Your ref
Our ref CPG/EST/3/10/8590
Date: 11 March 2013

**APPLICATION NUMBER 3/2013/0100
ELMRIDGE FARM, ELMRIDGE LANE, CHIPPING, PR3 2NY
GRID REFERENCE SD 595 405**

Wayne Selway MRICS FAAV
Land Agent
Property Group • PO Box 26 •
County Hall • Preston • PR1 8RE

Drawing Title:
Proposed Farm Building

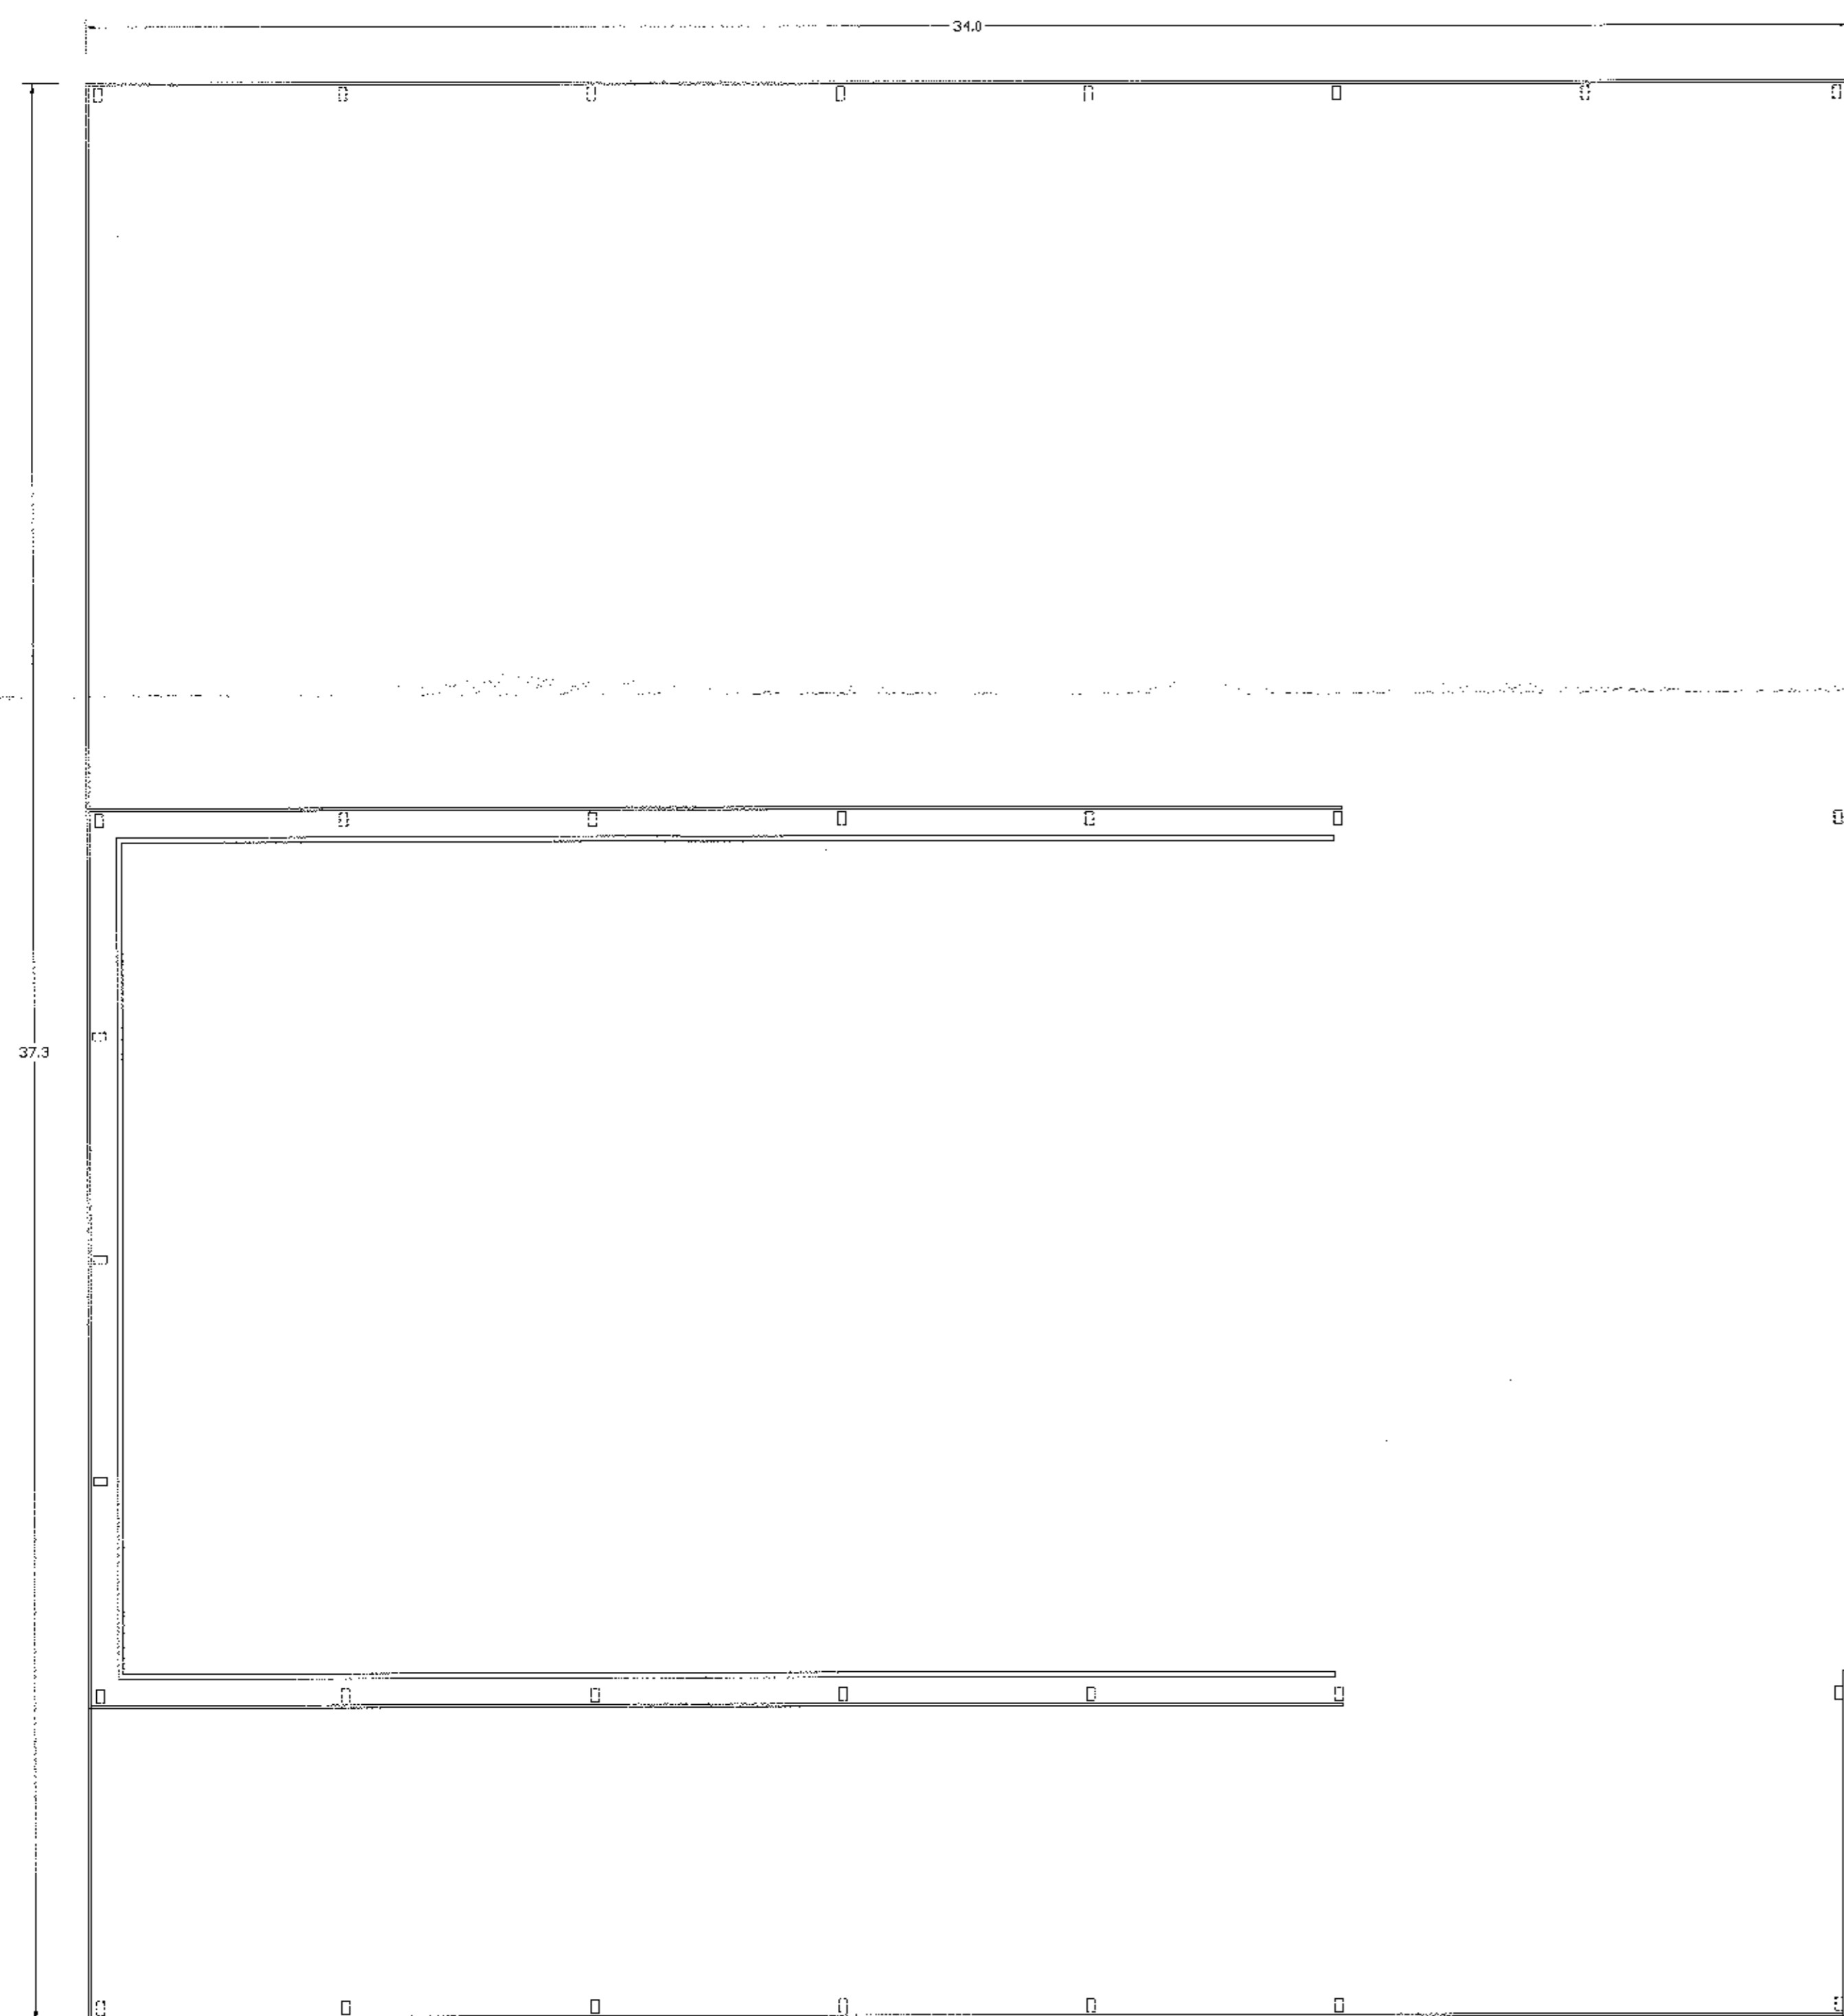
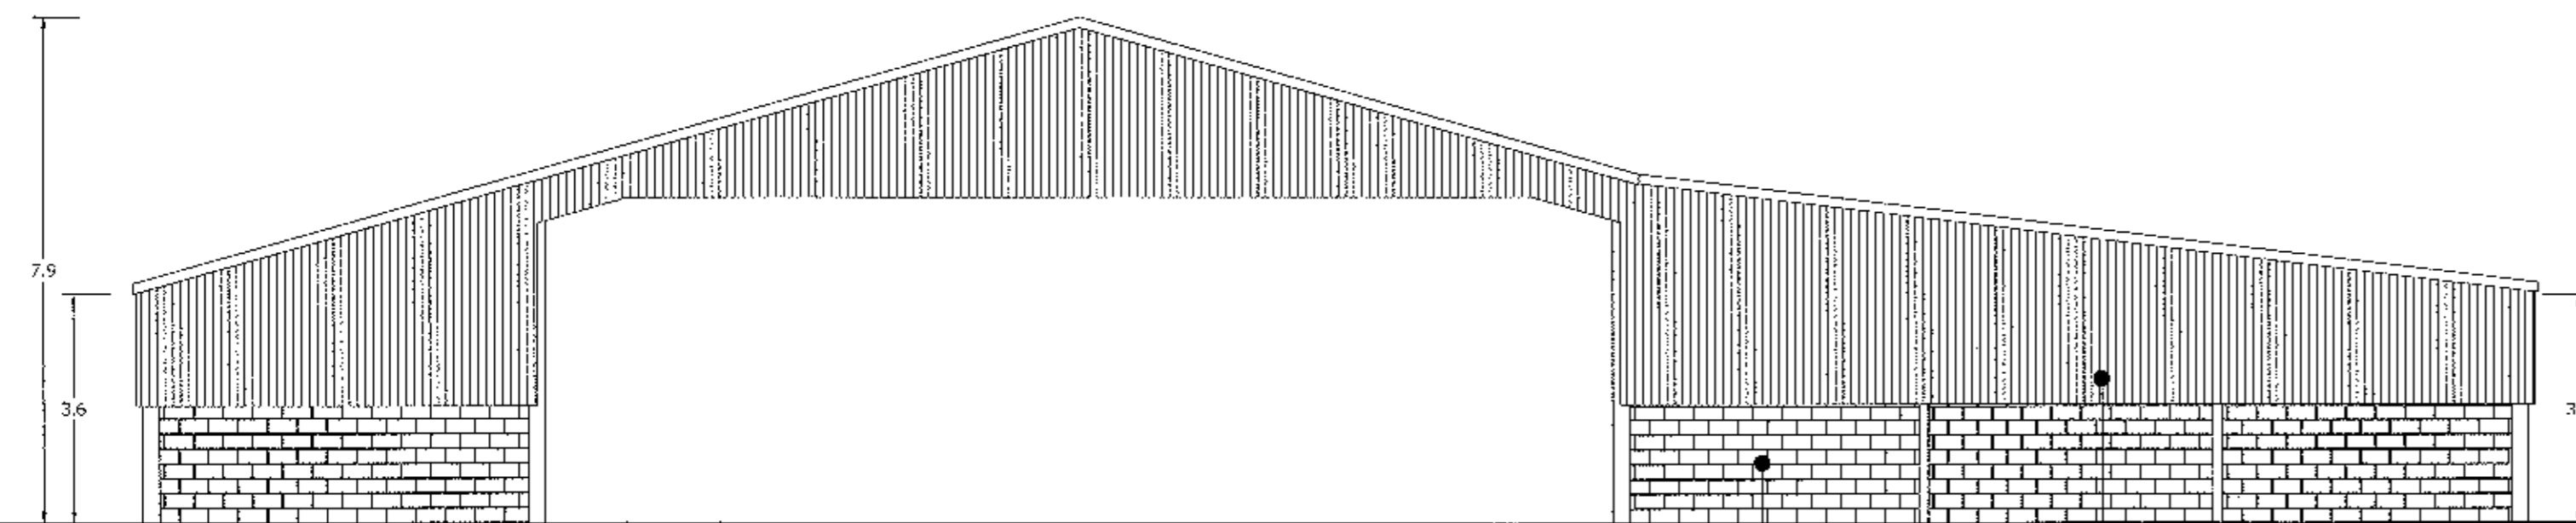
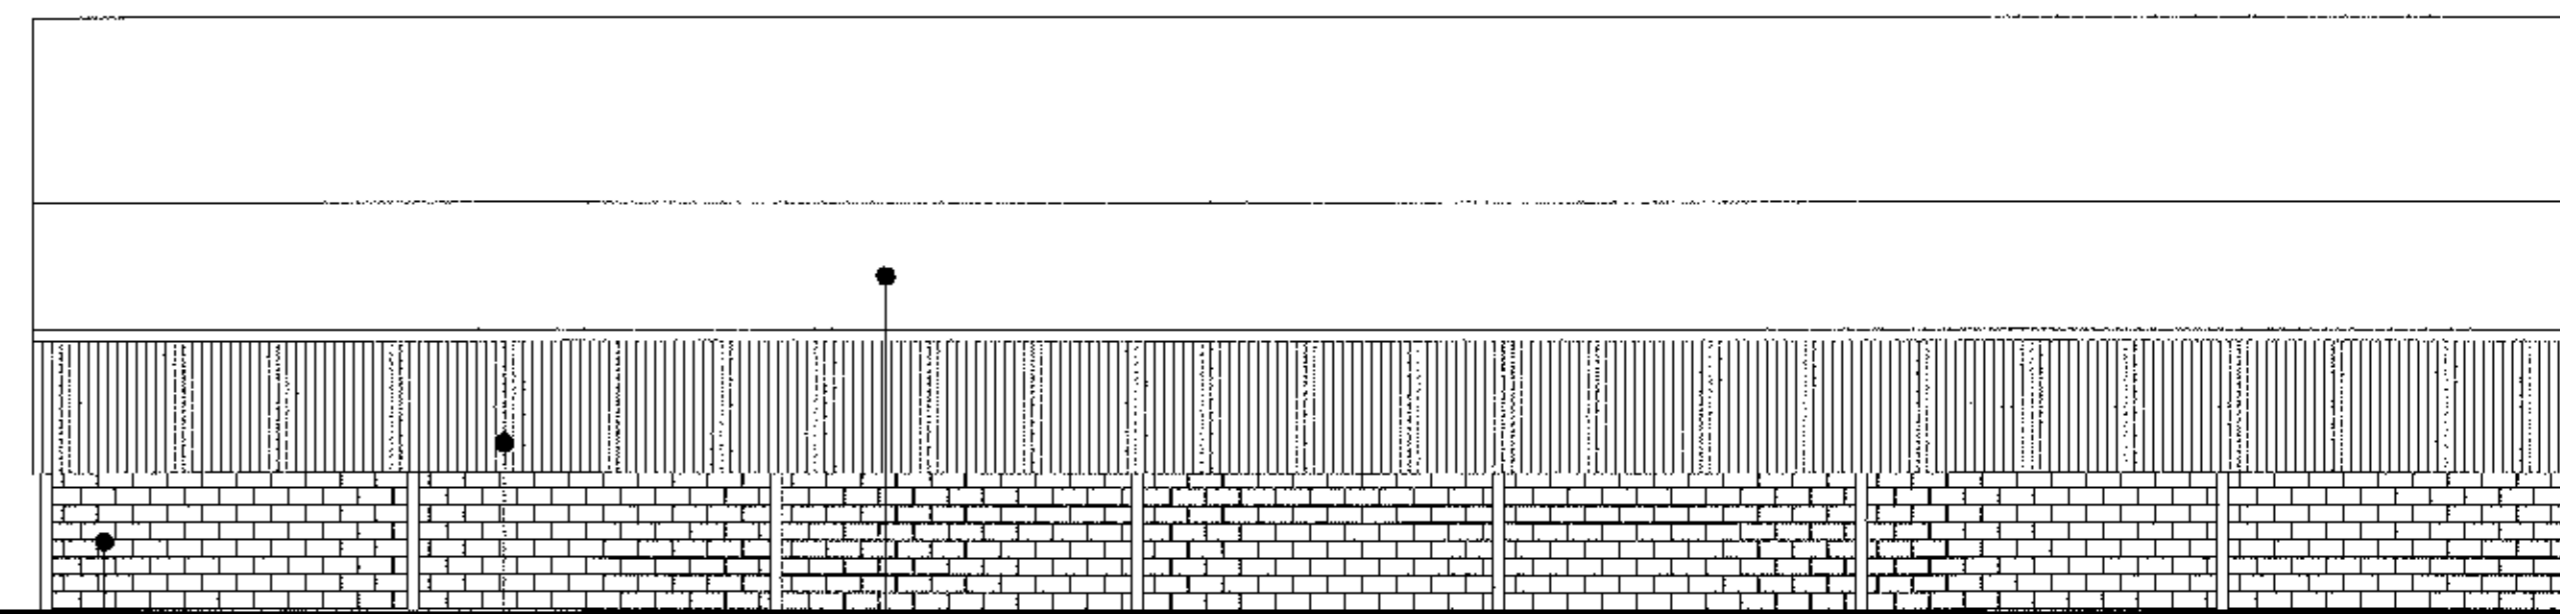
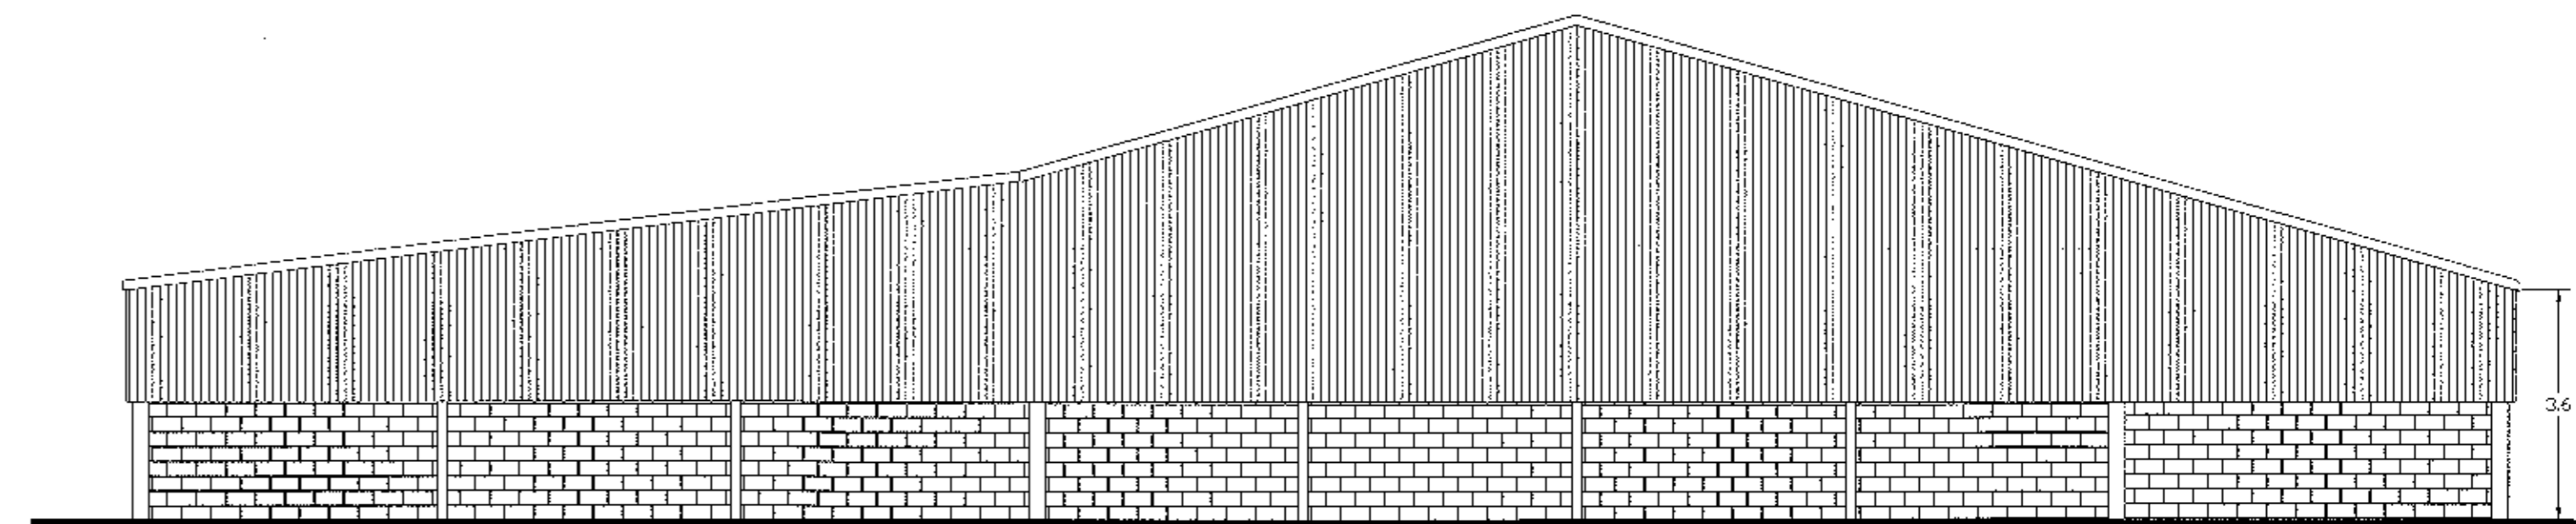
Notwithstanding this comment, the proposed size and design of the proposed building is on balance acceptable. The height of the building is high for the intended use, which is due to fact that the building to be recycled was originally used as a silage clamp. I would also comment that the doorways on the cattle section should be adjacent to the feed face to provide for ease of mucking out etc.

Limited information has been put forward concerning the proposed midden, however the size of the midden seems to be larger than required. In my opinion, the proposed yard is also larger than required.
